From: Dr Maria Byrne
Address: 24 Grove St, Birchgrove NSW 2041
Re: Western Harbour Tunnel and Warringah Freeway Upgrade, Environmental
Impact Statement: Project 1045; Application No: SSI 8863
Declaration: I have made no political donations in the past 2 years

Part 1: Inadequate data and assessment of the risks to human and environmental health due to disturbance of contaminated toxic sediments.

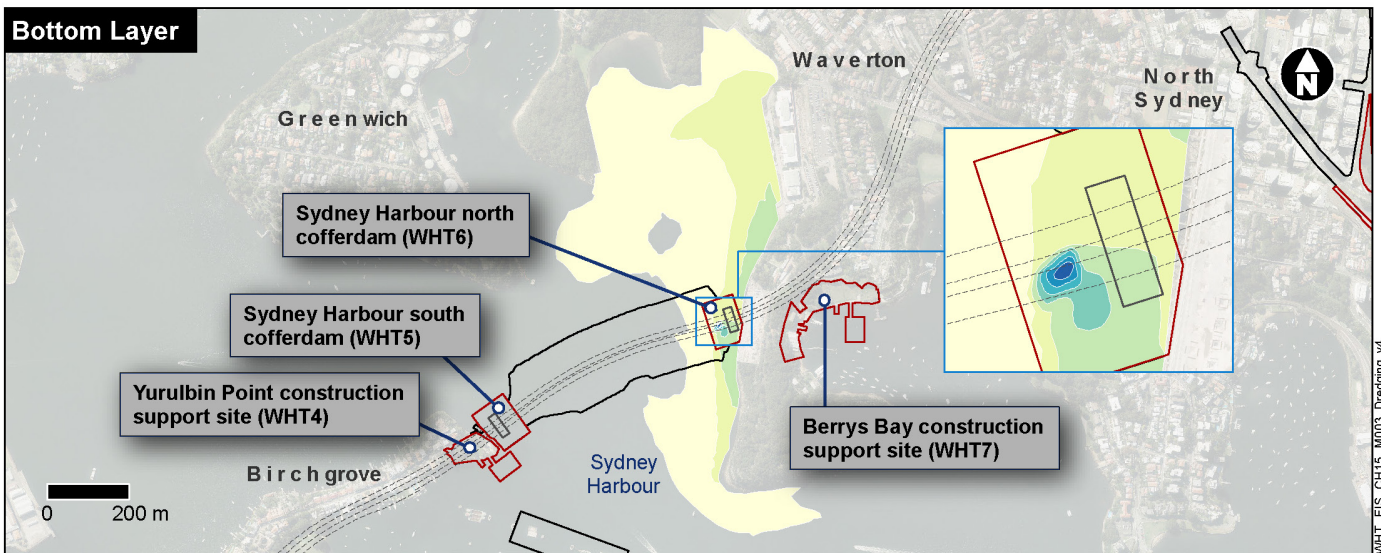
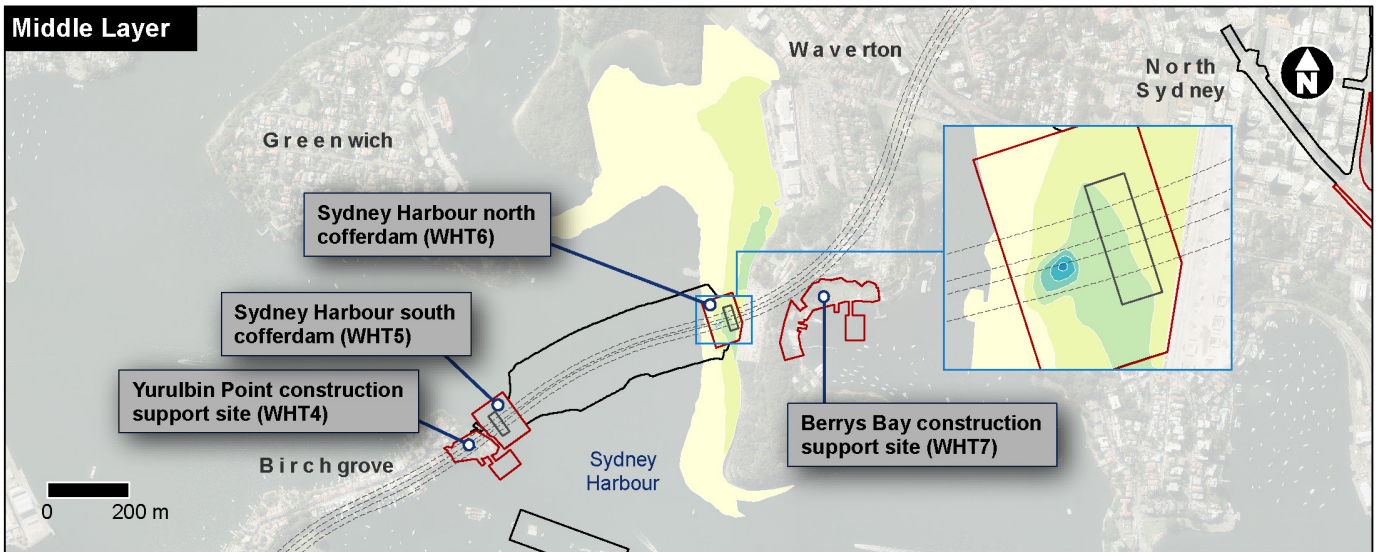
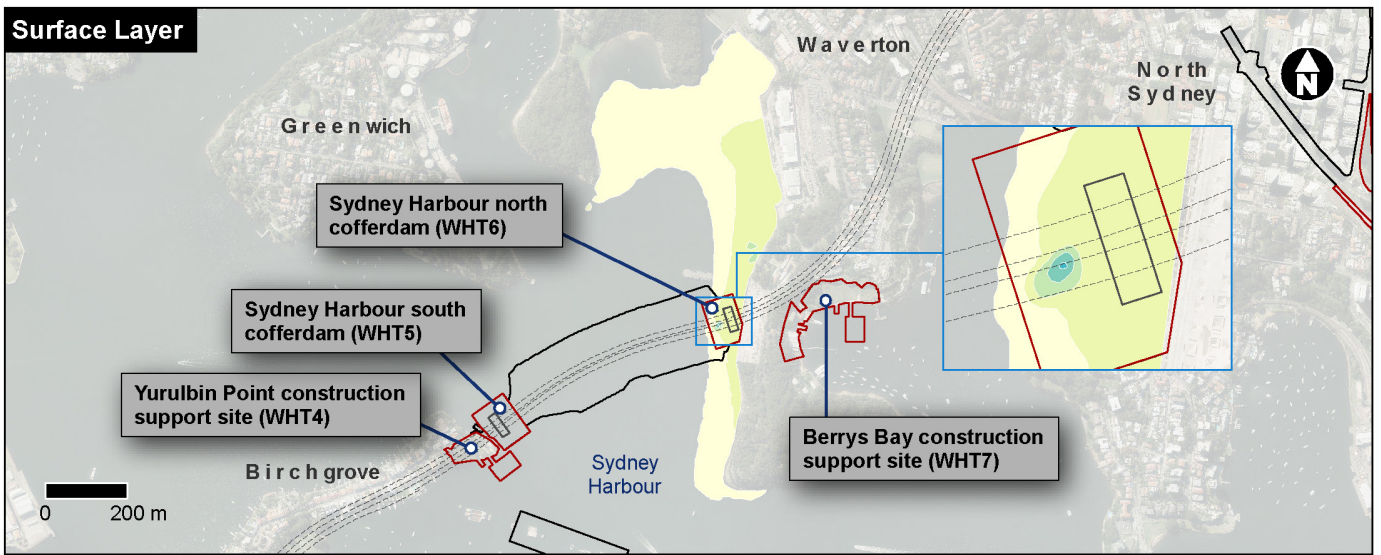
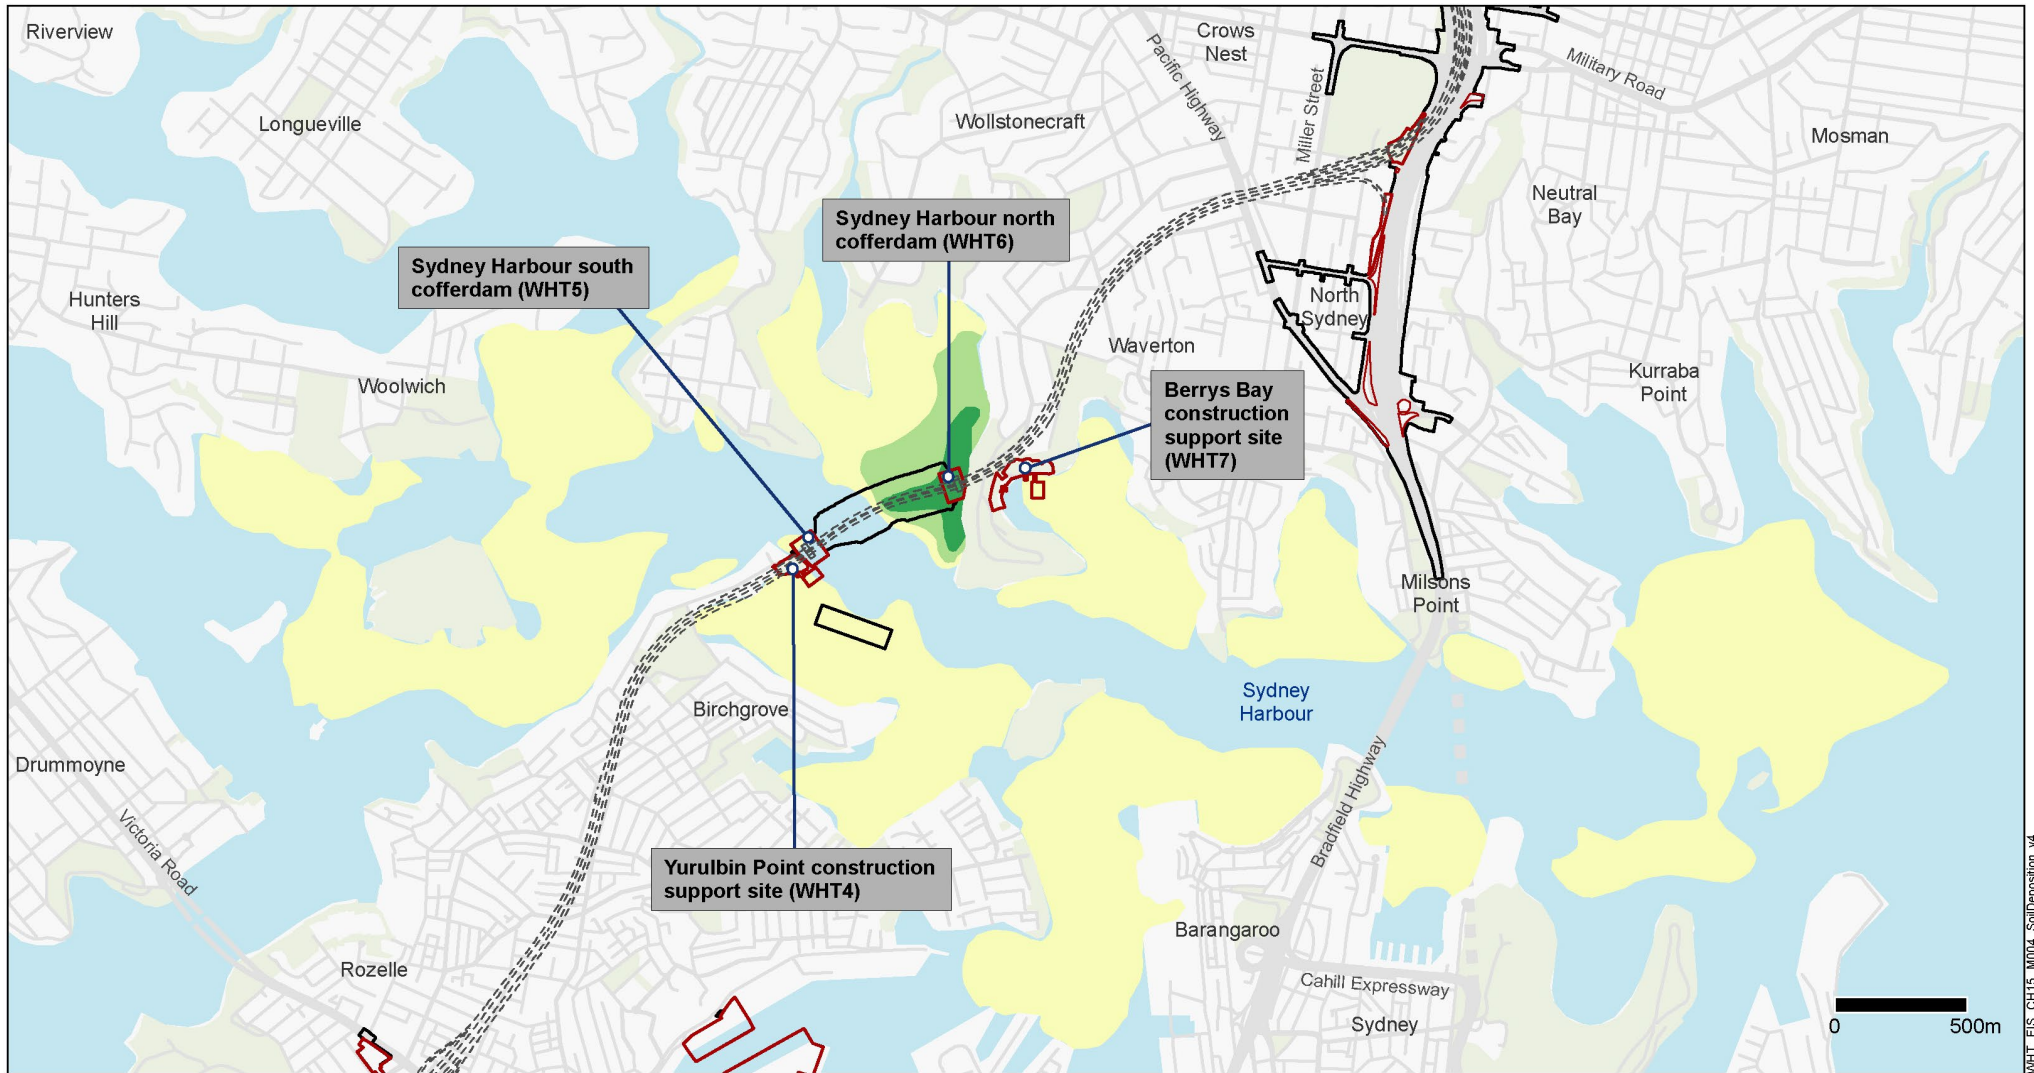
The predictive modelling of suspended sediment plumes and sediment deposition with regard to hydrodynamics simulations (p. 17) do not reflect what is known about water movement and waves in the dredge area (SMH, 18 March 2020) and does not appear to include the dynamics of shallow water areas of the WHT project. In my experience, being on the water regularly, due to wind, waves, tides and activity the waters around Yurulbin Point and across to Berrys Bay are highly dynamic and water movement would certainly cause dispersal of dredge plumes. Importantly, in East Coast Low conditions winds come directly into the WHT project area. This has not been mentioned. The Proponents do not have any contingency management plans for extreme weather events. Targeted research and more rigorous data are needed on the hydrodynamic-sediment plume transport in the exact area of WHT operation.

Figure 16-3 Sydney Harbour marine sediment profile

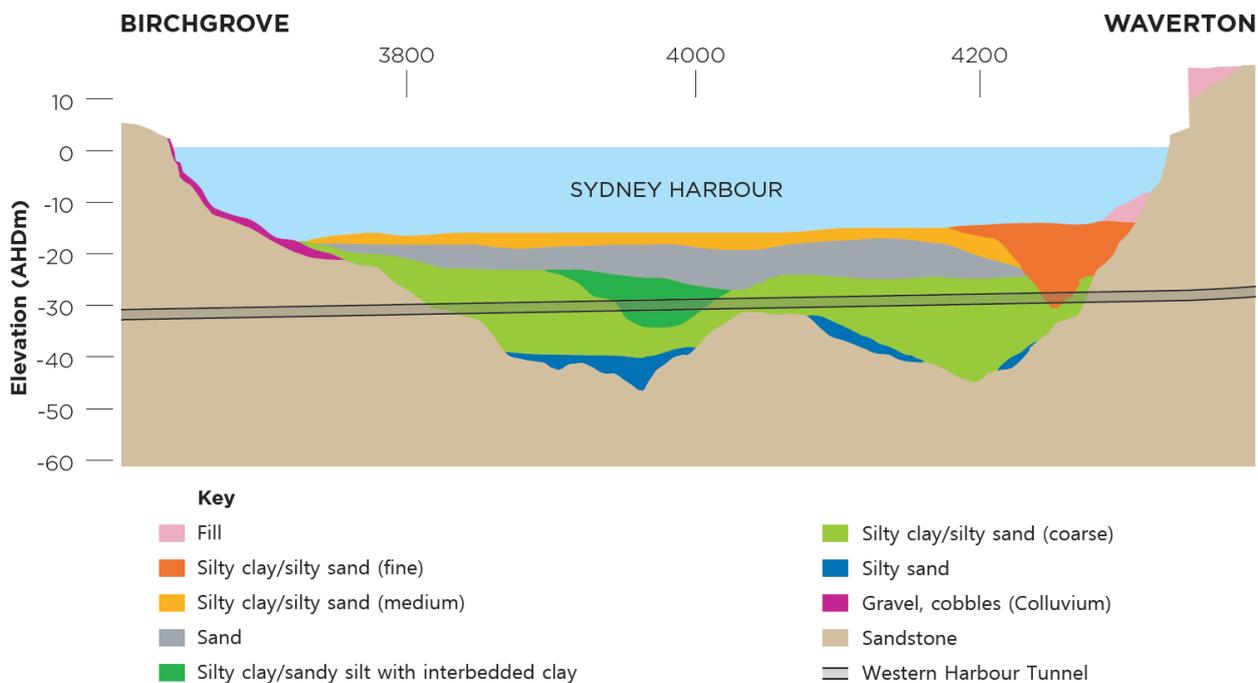
Appendix M lacks veracity as there are no quantitative data on sediment contaminants. Use of "x" in Table B.1 to indicate toxics of concern is inadequate. Data on concentration of contamination and methods used must be made available with maps showing sites of sample collection. No data were provided in Appendix M to support the findings. There is no information on how the samples were collected, how they were handled, how analysed, how many samples per site and at what depth, etc. To meet the SEARS requirement, replace the "x's" in Table B. with mean concentration levels, standard error/deviation and sample size. A methods section is needed to explain how this work was done and the quality assurance – quality control measures in place. As a matter of urgency and to provide the transparency required for independent assessment, the proponents should release the data in DGPA (December 2017). Importantly, there are no data on the sediment from Berrys Bay, an omission that does not comply with the SEARS.

In parallel with the sediment contaminant load there is a strong possibility that WHT construction will mobilise acid sulphate soil/sediment (ASS) leachate with the release of sulphuric acid into the environment. These leachates reduce seawater pH and thereby increase the bioavailability of metals and other contaminants in the sediment. The combination of ASS and chemical mixtures in sediment and pore water presents a very high risk to marine life including mortality. This was not considered in the EIS.
